# Modification of Development Consent

**Development consent:** SSD\_5824 granted by the delegate of the Minister for Planning on 25 September 2015

Development of One Carrington Street including:

**Modification:** SSD 5824 MOD 3: the modification includes:

scale	As indicated	drawing no.
drawn	AP	DA0007-2
paper size	B1	
checked	RO	issue
project no	m: 958 a: 120298.00	Rev 00

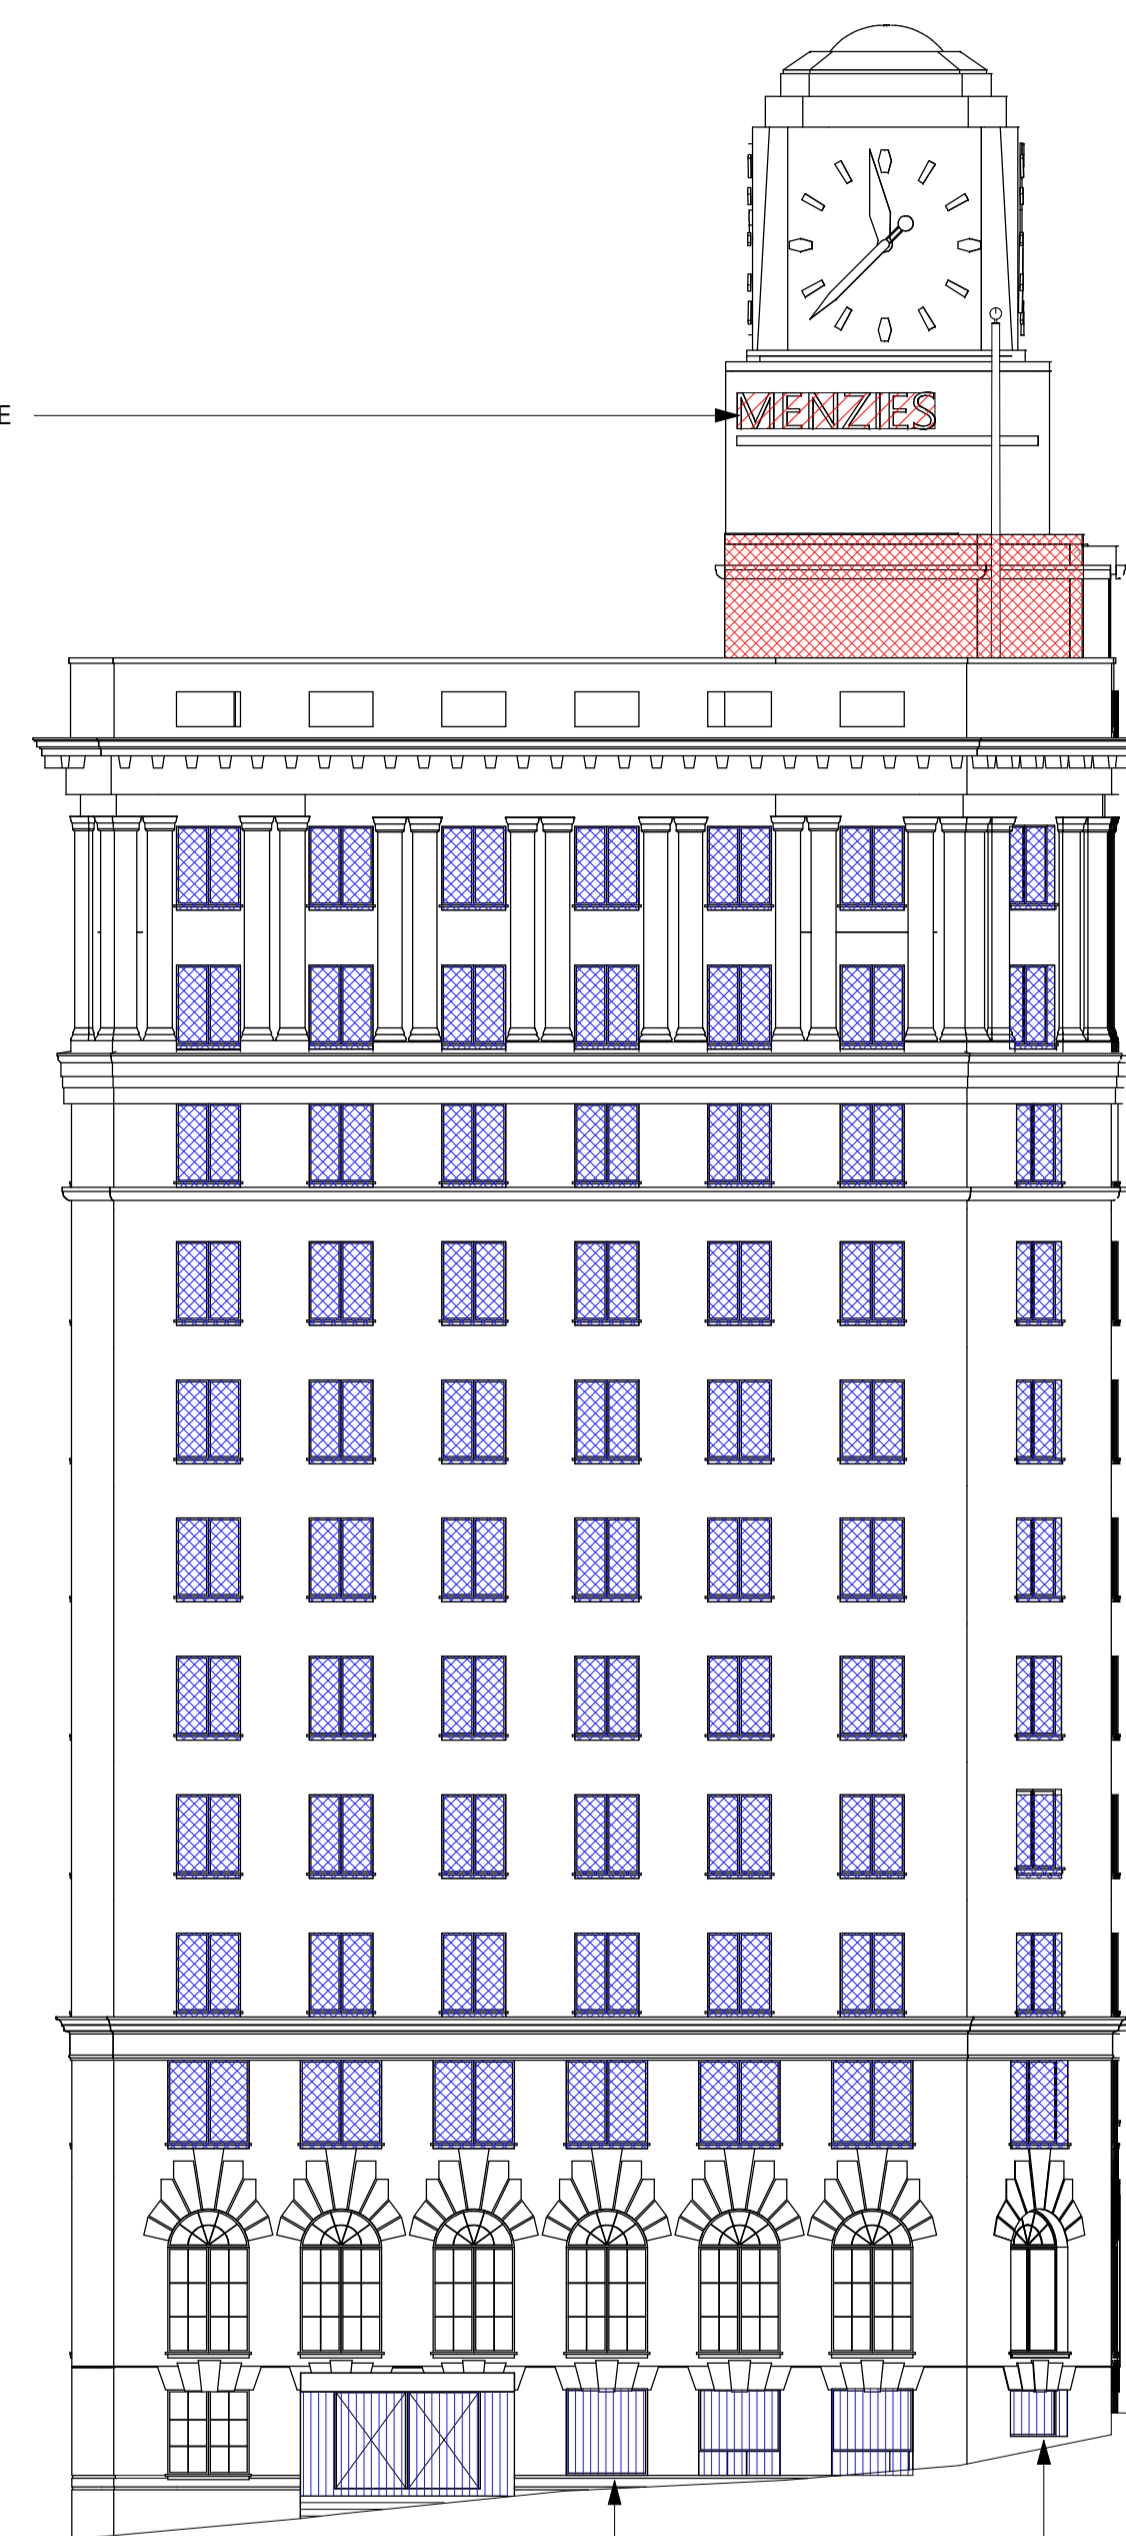
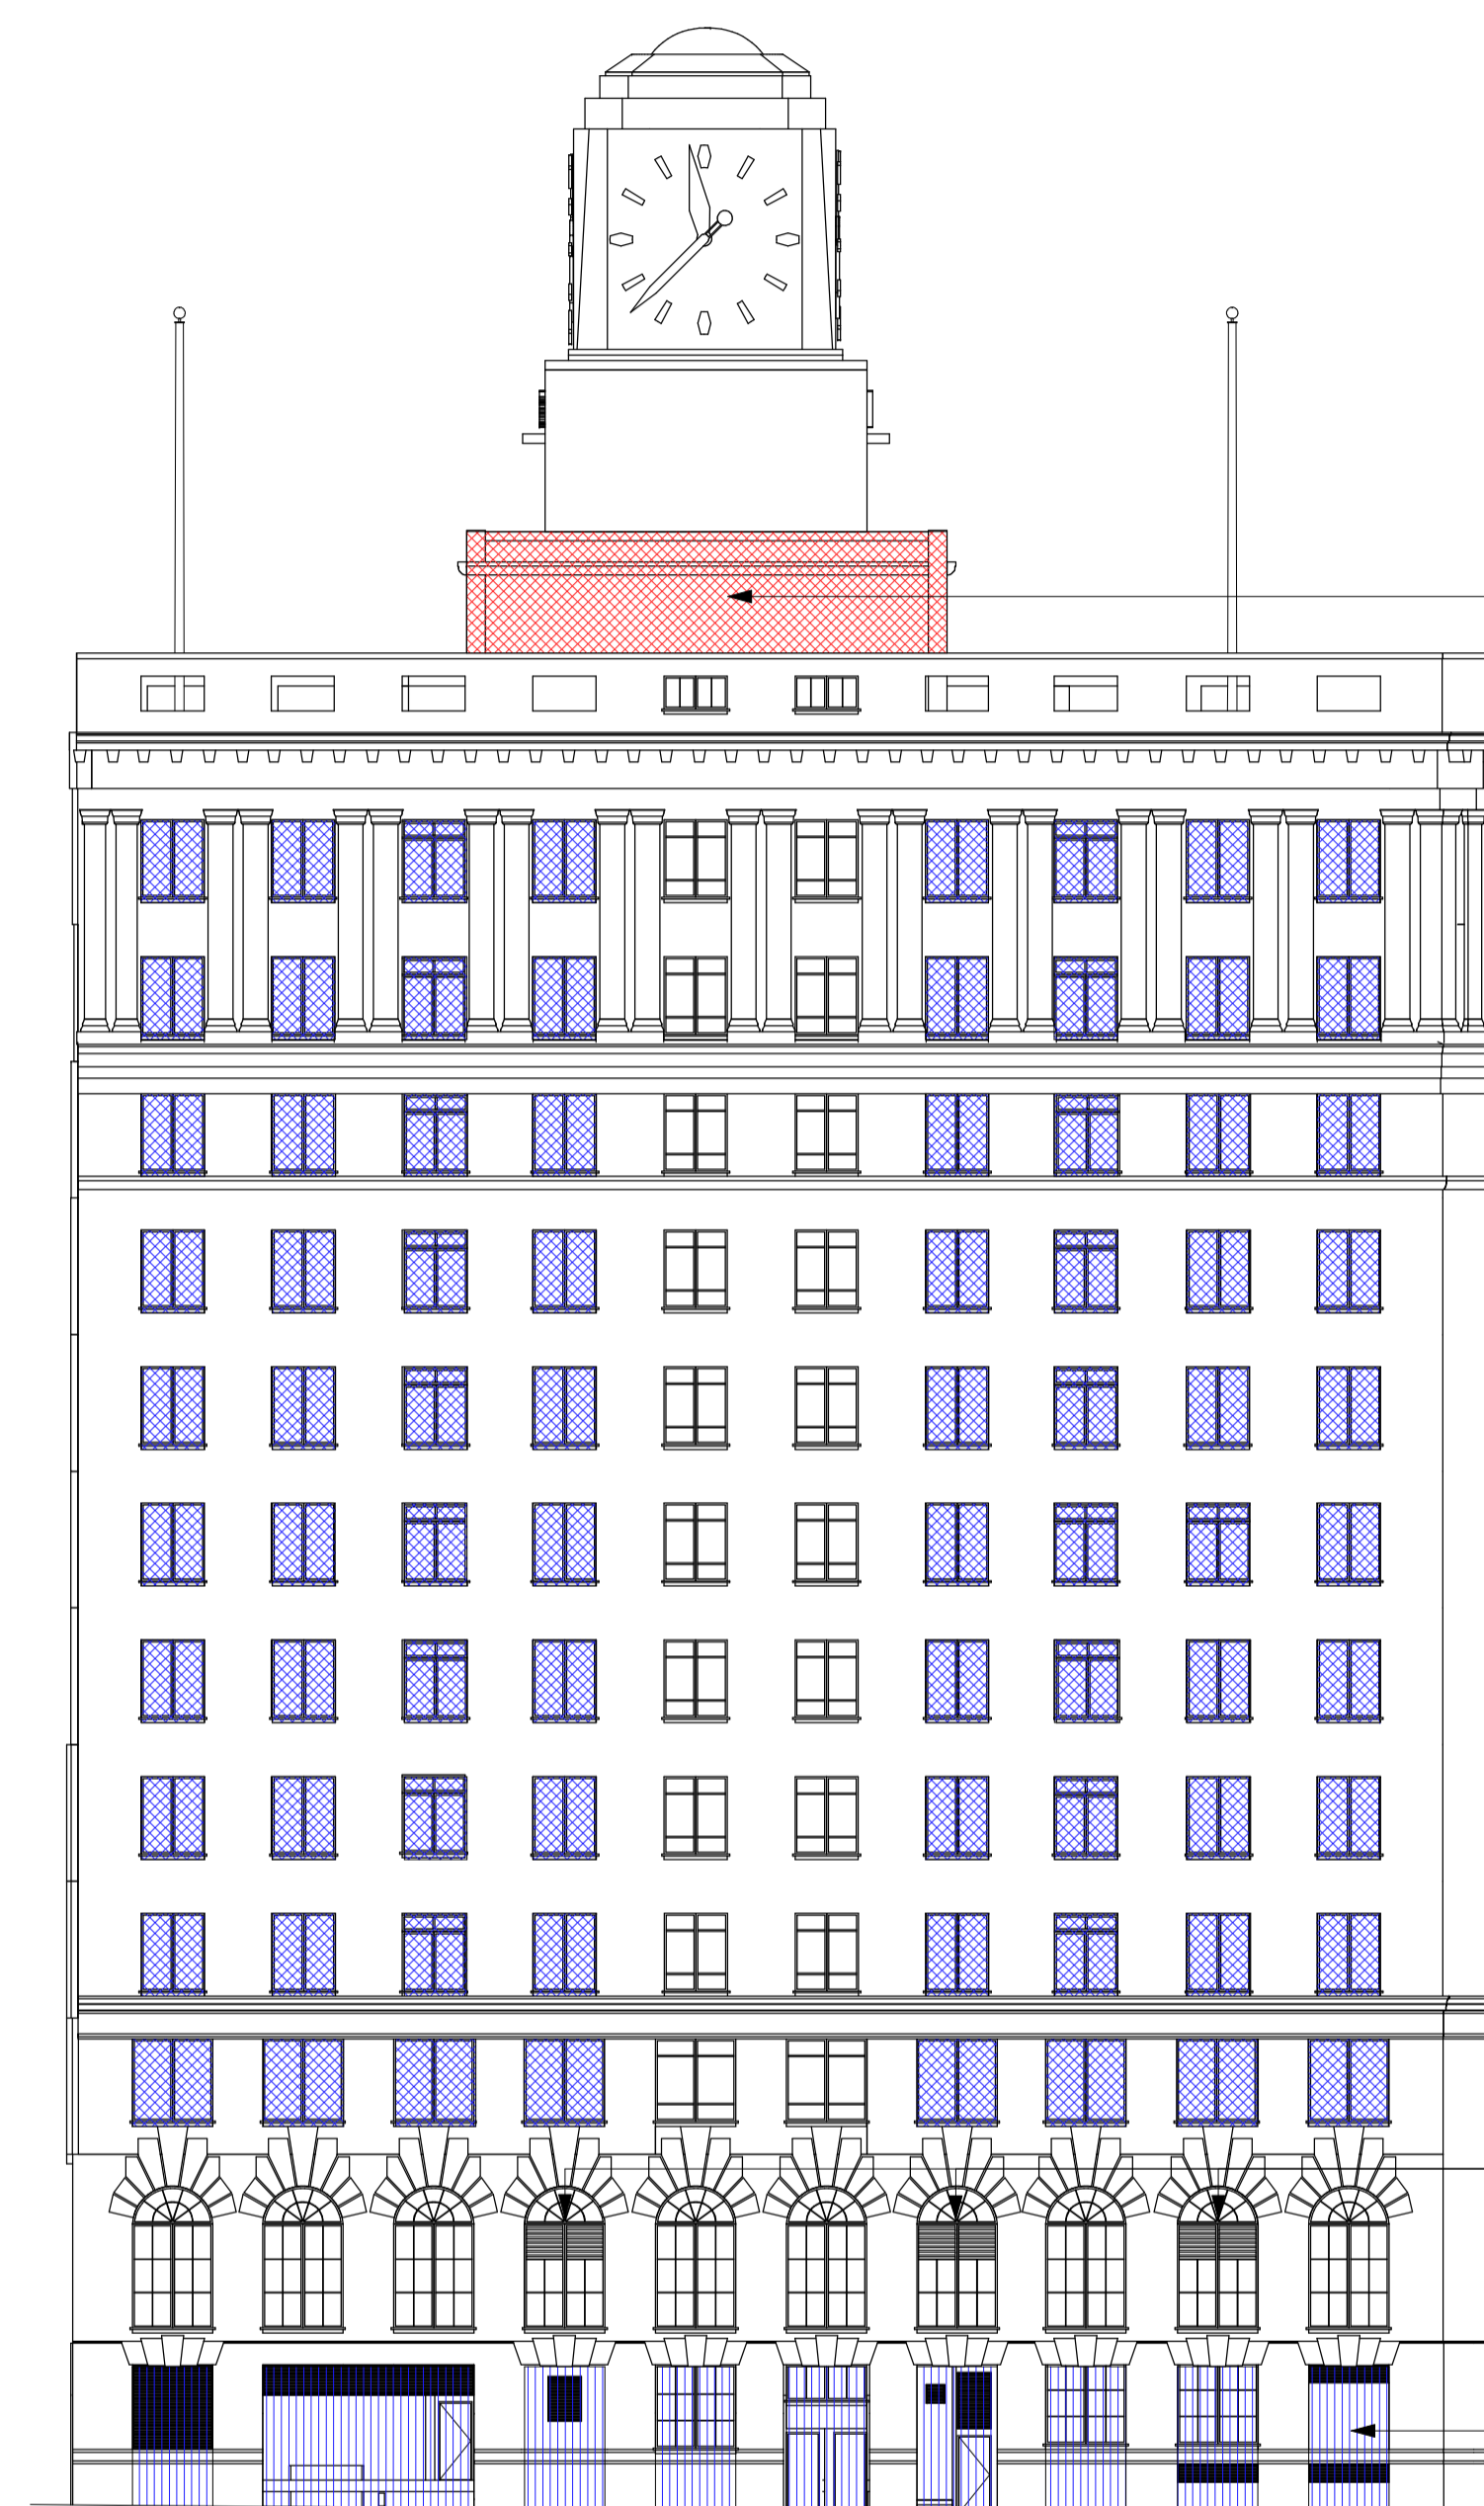
- increase the extent of internal demolition works within Shell House.

<b>Architectural (or Design) Drawings prepared by Make + Architectus</b>			
<b>Drawing No.</b>	<b>Revision</b>	<b>Name of Plan</b>	<b>Date</b>
DA0002	00	General Notes and Symbols	19.03.2014
DA0006	00	Demolition Plan – Site	17.03.2014
DA0007	<del>01</del> <b><u>03</u></b>	Demolition Plan – Shell House	<del>25.09.2015</del> <b><u>21/09/2016</u></b>
DA0008	00	Demolition Plan – 285 George Street	17.03.2014
DA0009	02	Excavation Plan	25.09.2015
DA1000	00	Existing Site Plan	19.03.2014
DA2000	02	Proposed Site Plan	25.09.2015
DA2002	02	Lower Basement Level	25.09.2015
DA2003	02	Basement Level	25.09.2015
DA2004	02	Hunter Connection Level	25.09.2015
DA2005	02	Concourse Level	25.09.2015
DA2006	02	George Street Level	25.09.2015
DA2007	02	Wynyard Lane Level	25.09.2015
DA2008	02	Carrington Street Level	25.09.2015
DA2009	02	Upper Ground Level	25.09.2015

- (a) **Excluding minor demolition required for investigative works and installation of the façade retention system, prior to the issue of a construction certificate in relation to the demolition of the additional internal structure and floors of Shell House including the Clock Tower, approved under Section 96 (Mod 3), the following is to be submitted to the satisfaction of the Manager Heritage and Urban Design City of Sydney:**

**D16a. The internal demolition works within Shell House shall be carried out in accordance with the recommended vibration minimisation mitigation measures contained within the letter from Multiplex dated 31 October 2016.**
